320190763P

Feazer Cottage

Re: Documentation to support application for variation/removal of conditions relating to application number 3/2019/0217

Conditions to be varied or removed:

Drawing no 6003/a

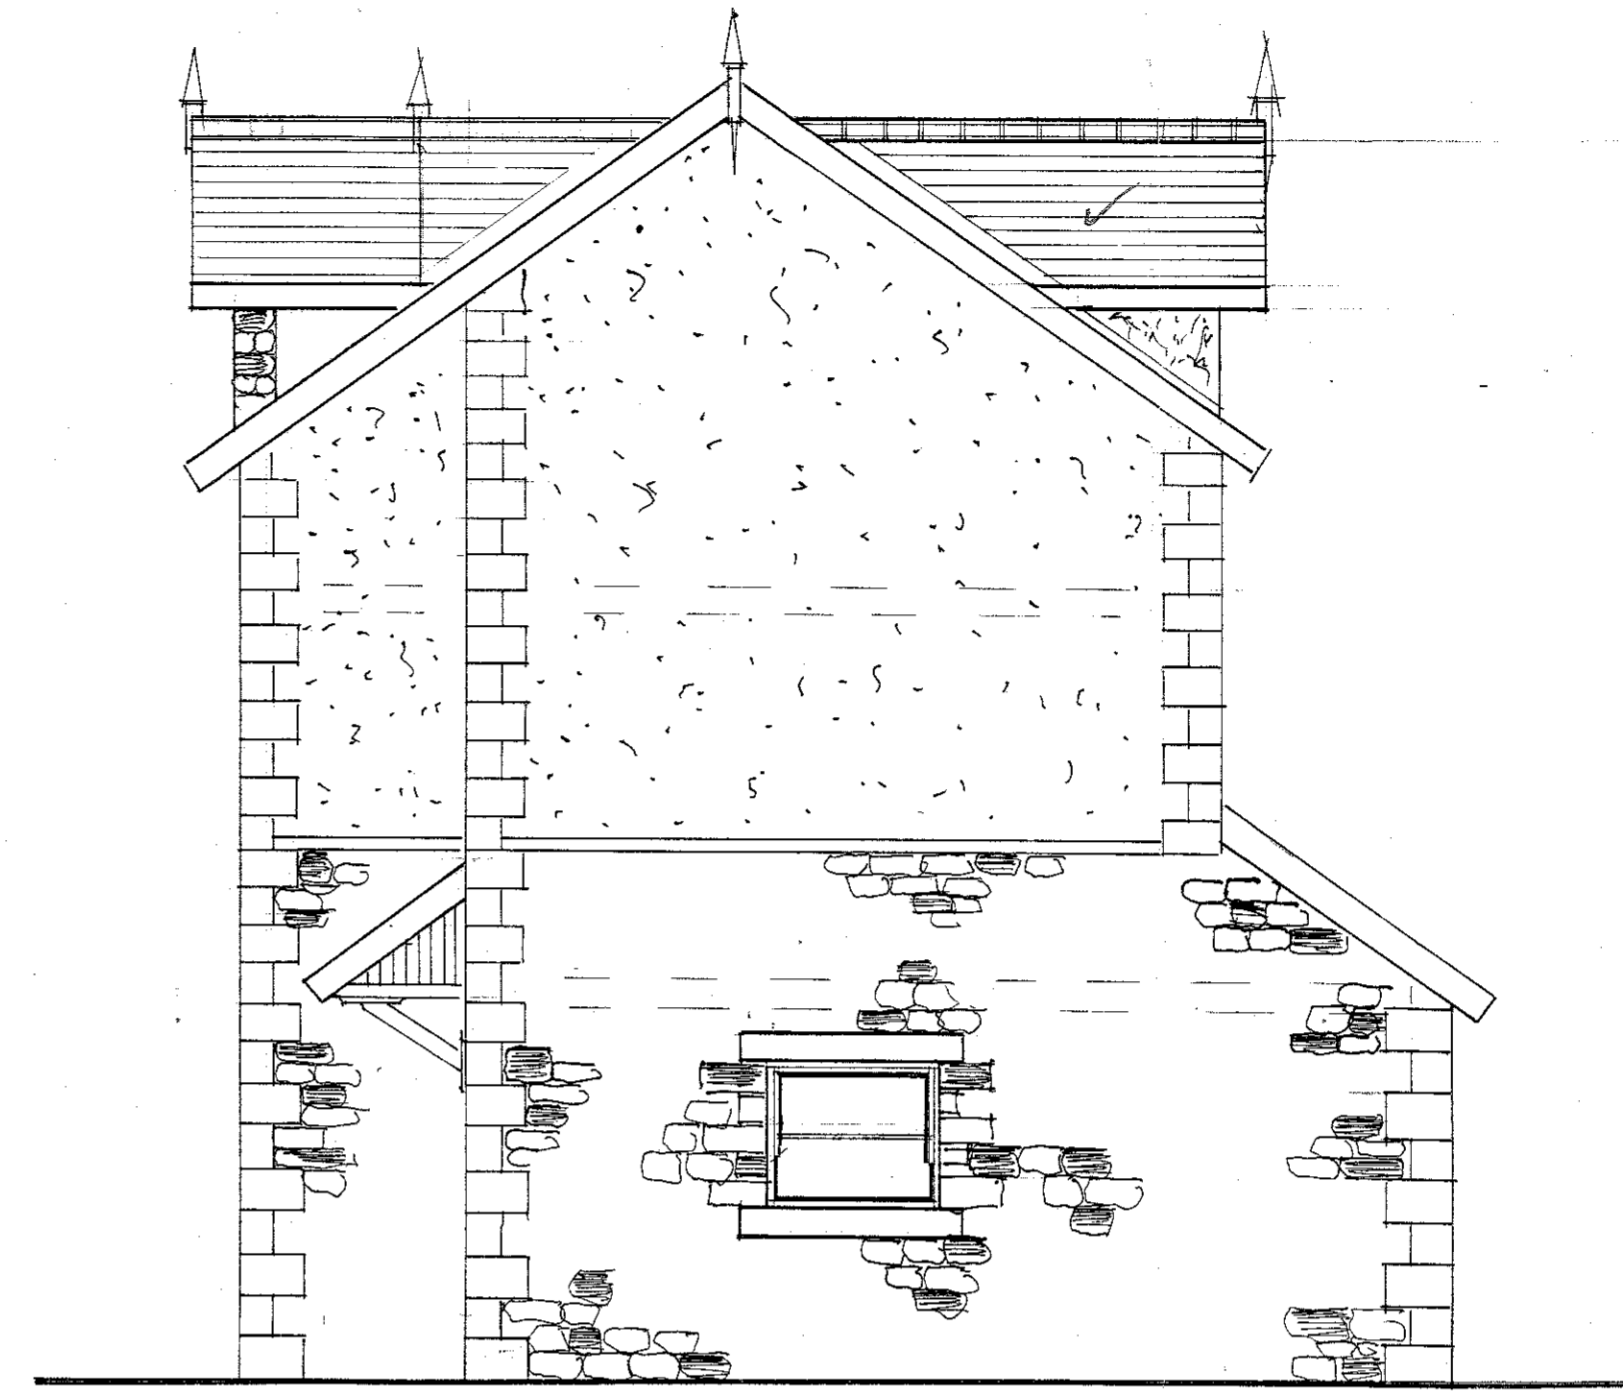
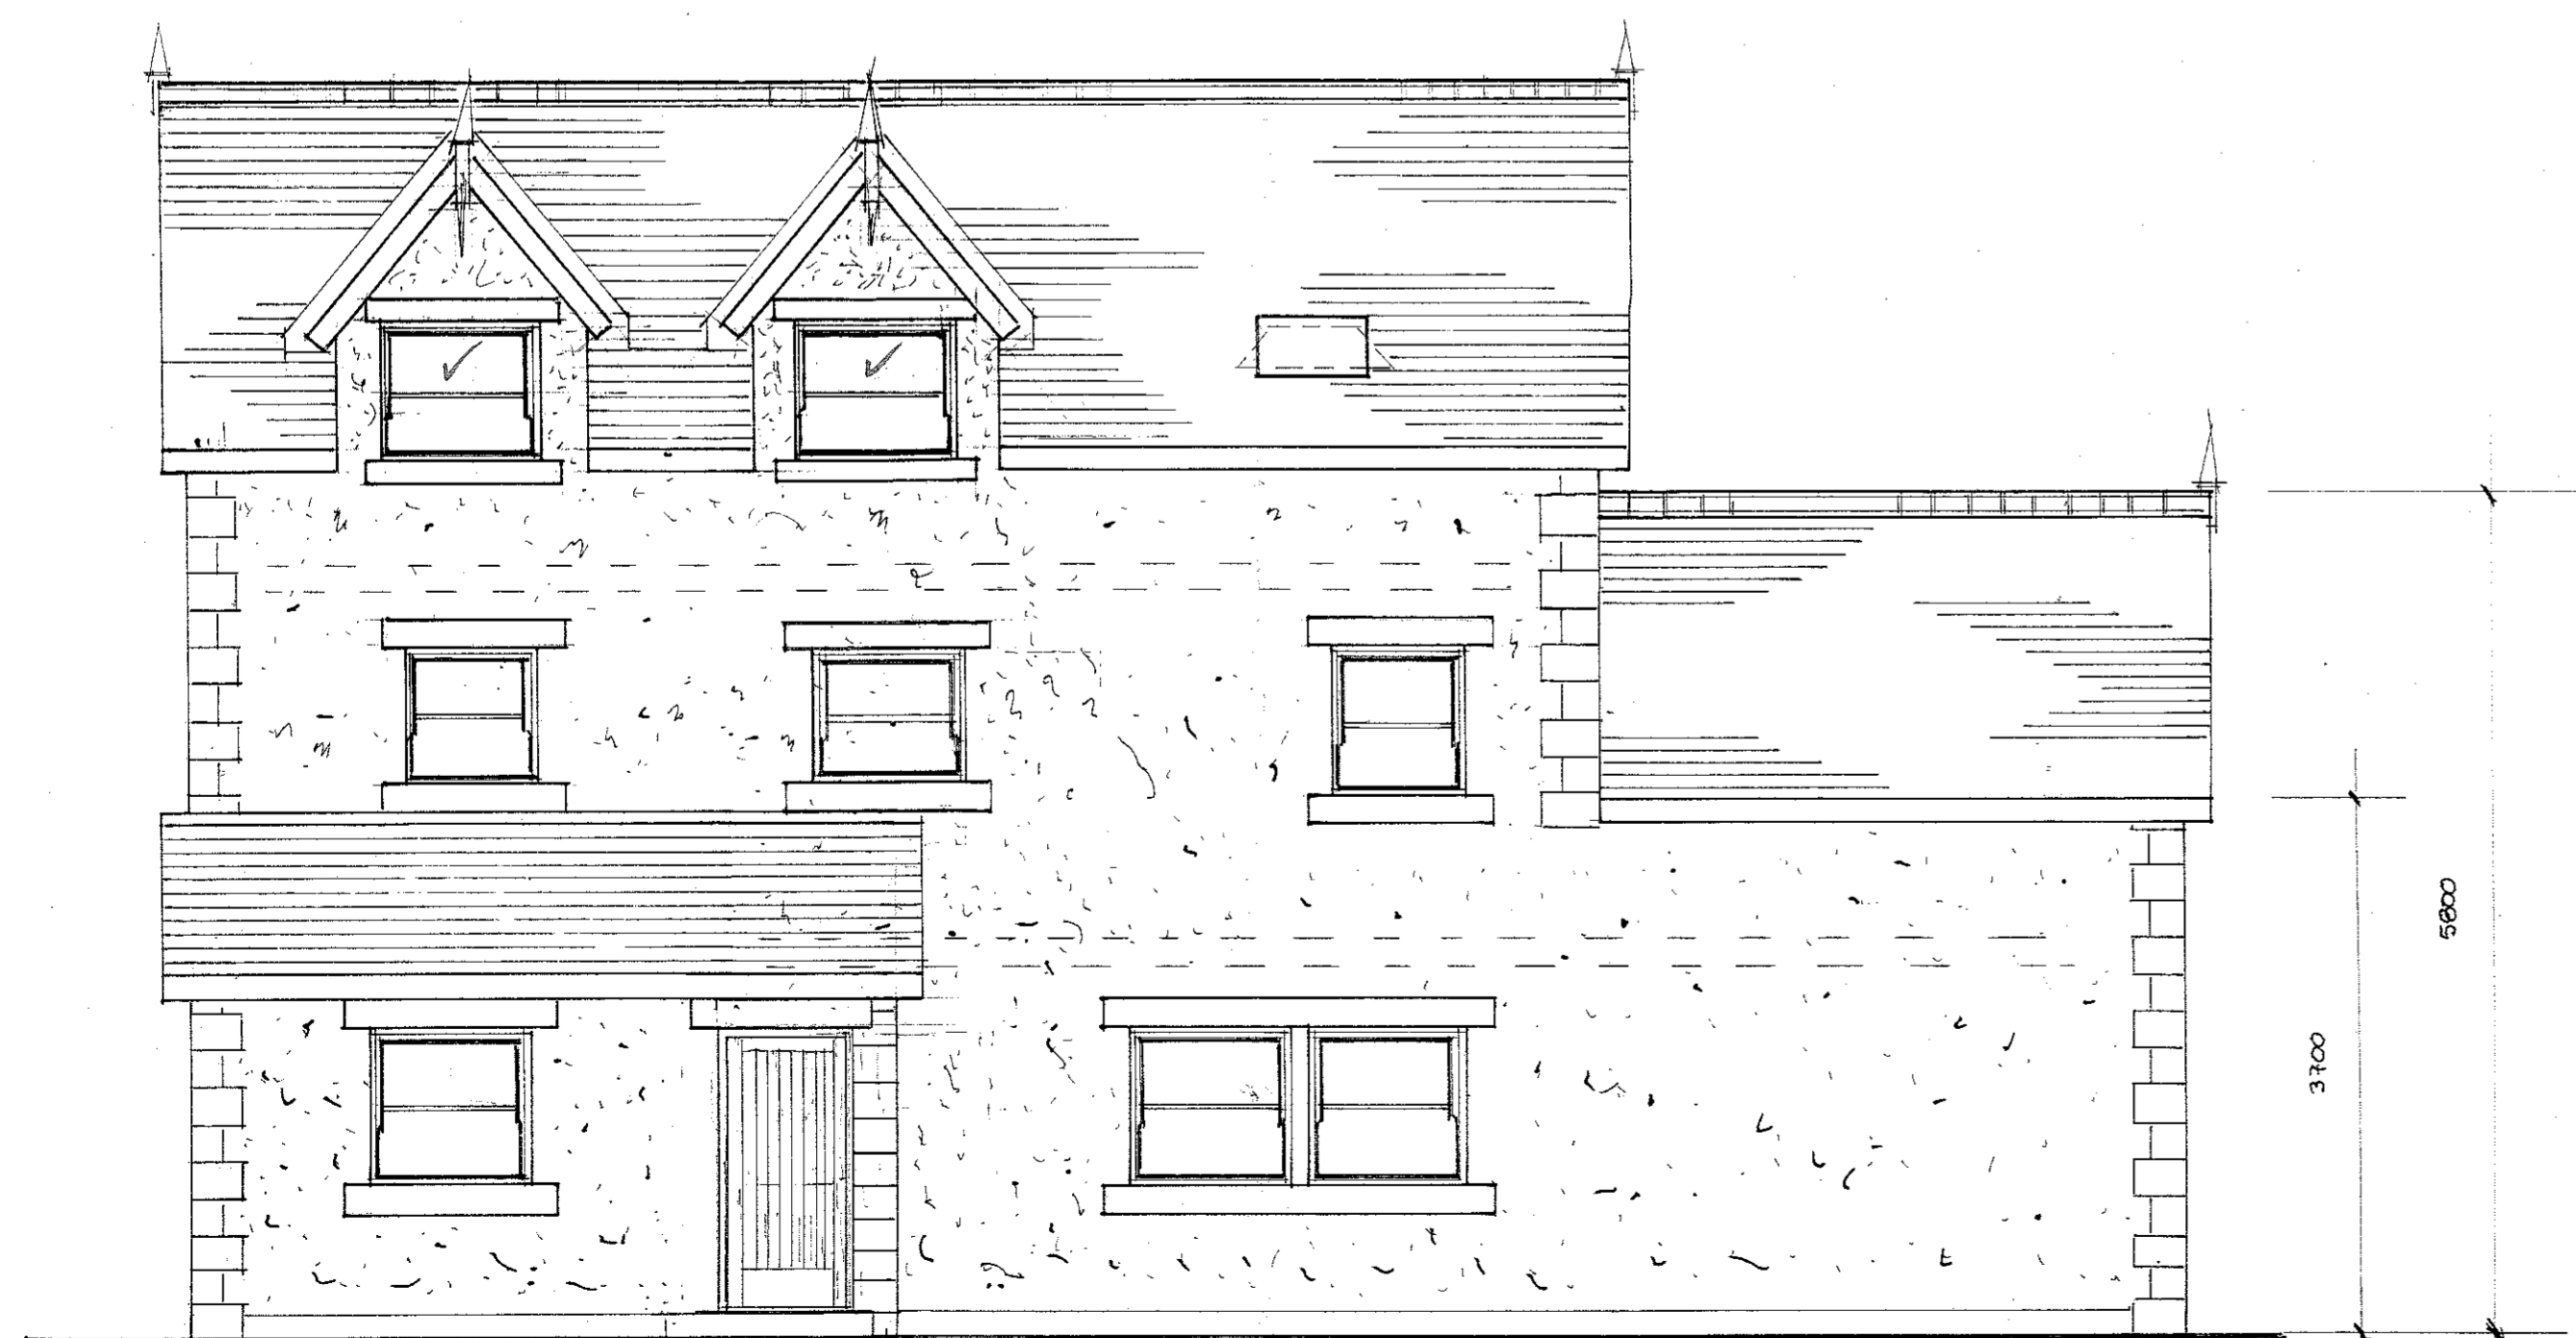
We would like to submit an application to vary this condition due to a redesign and reduction in property size by approximately 20% for Plot A, previous application which has now been withdrawn 03/2019/0476.

6003 Plot A Elevation (Redesign of Plot)

6003a New Plot A Elevation
